KITITAS COUNTY

MEMORANDUM

SUBJECT: Harmon Short Plat SP-10-00007

The following shall be conditions of preliminary approval:

HARMON SHORT PLAT

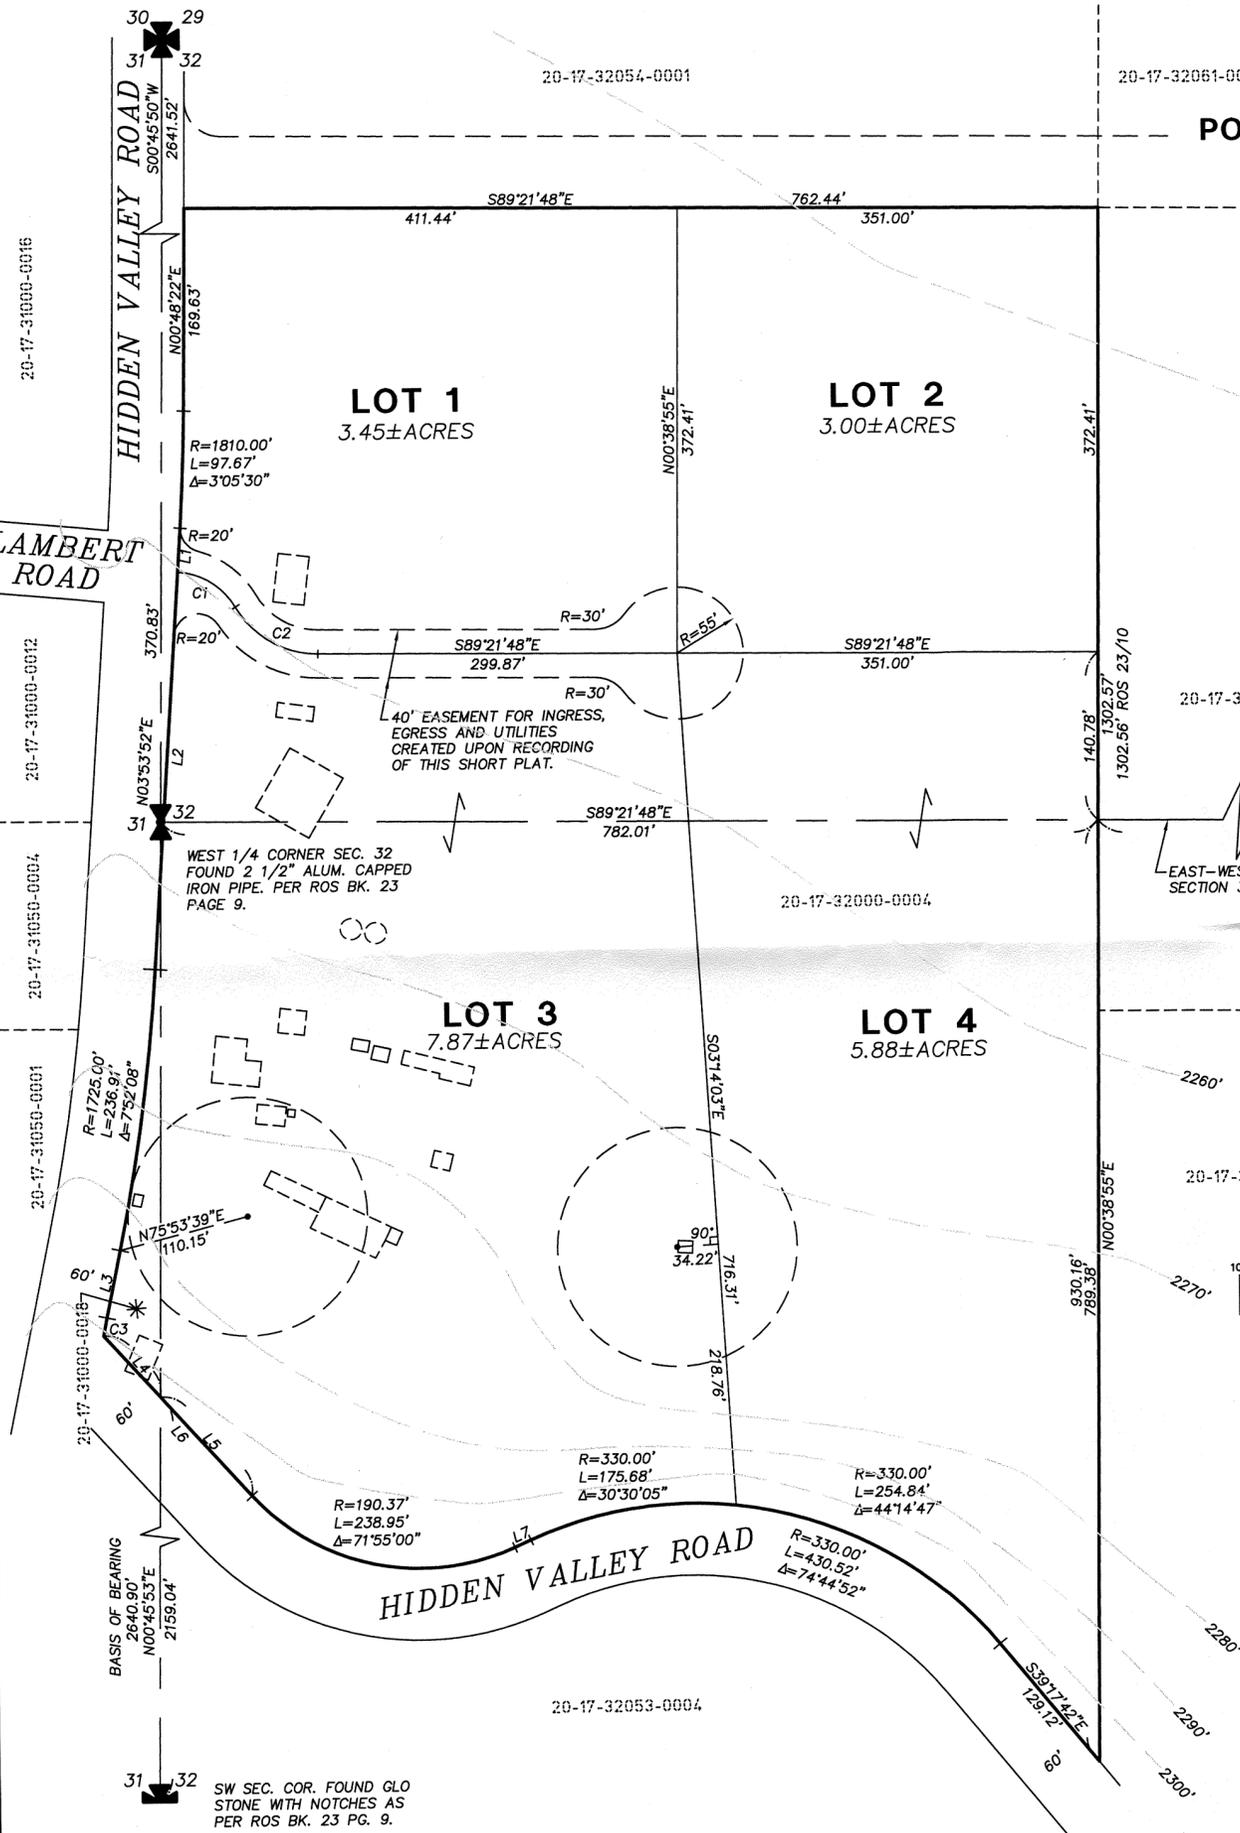
3. Private Road Improvements: Access from Hidden Valley Road shall be constructed to meet or exceed the requirements of a High-Density Private Road that serves 3-14 tax parcels. See Kittitas County Road Standards, 9/6/05 edition.

- a. Access easements shall be a minimum of 40' wide. The roadway shall have a minimum width of 20', with 1' shoulders, for a total width of 22'.
 - b. Minimum centerline radius will be 60'.

- c. Surface requirement is for a minimum gravel surface depth of 6".
 - d. Maximum grade 8% flat, 12% rolling or mountainous.
 - e. Stopping site distance, reference AASHTO.

- j. All easements shall provide for AASHTO radius at the intersection with a county road.
 - k. A paved apron shall be constructed at the intersection of the proposed private intersection and the county road.

4. Cul-de-Sac: A cul-de-sac turn-around having an outside right-of-way or easement diameter of at least 110 feet shall be constructed at the closed end of all dead-end roads serving 3 or more lots. The driving surface shall be at least 96 feet in diameter. Cul-de-sacs must also conform to the requirements specified by the 2006 International Fire Code. Contact the Fire Marshal regarding any additional cul-de-sac requirements.
